Your ref: SSD-31179510
Our ref: DOC25/1094210

Subject: Response to Submissions Amendment Report – Gregory Place Build-to-Rent located at 2A Gregory Place, Harris Park (SSD-31179510)

CPHR advice on RTS Amendment Report - Gregory Place Build-to-Rent located at 2A Gregory Place, Harris Park (SSD-31179510)

FIGURE No. **10**

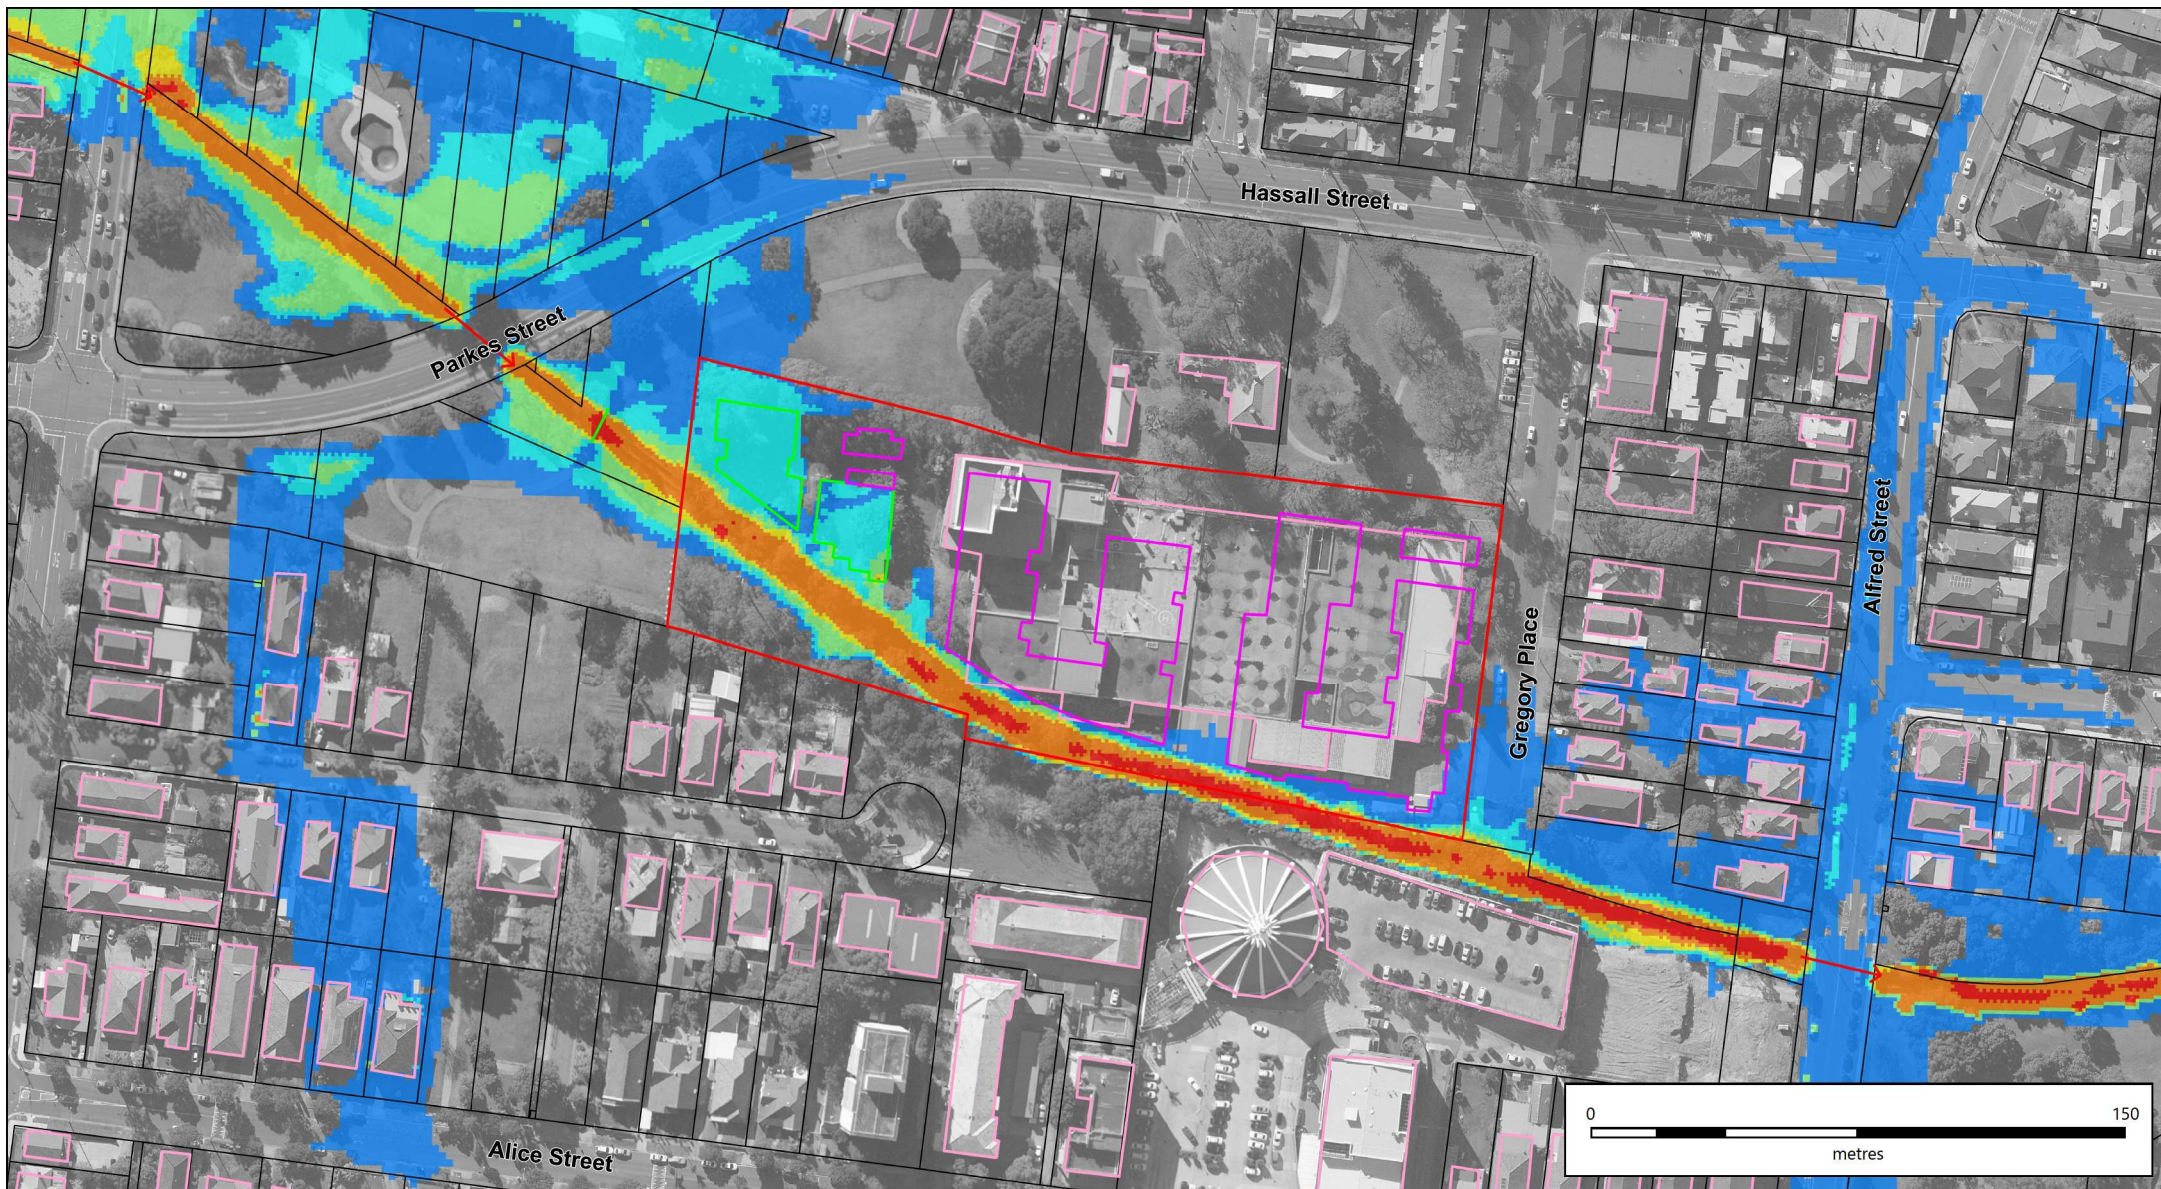
<i>Extent and Timing</i>	Pre-determination
2	<i>Flood impacts</i>	PMF impacts have not been mapped as required. Recommended action: Map and discuss flood impacts in the PMF separately for the Clay Cliff Creek and the Parramatta River.
	<i>Extent and Timing</i>	Pre-determination
3	<i>Flood risk</i>	While the FERP has used results of Council's Parramatta River Flood Study (Stantec, 13 June 2024) for the Parramatta River PMF, the Updated Flood Assessment has not presented mapping or discussion of Parramatta River PMF. The site is currently used for industry, and the proposal is for residential development. Given the highly constrained nature of the site, detailed consideration should be given to the suitability of the site for residential use. Residential use carries a higher flood risk profile than employment uses including longer and overnight occupation and the potential higher vulnerability of occupants such as children. Industrial facilities can close early before a flood and can be evacuated more easily. Recommended action: • Provide mapping and discussion of Parramatta River PMF and how it impacts use of the site. • Provide detailed consideration as to the suitability of the site for residential development.
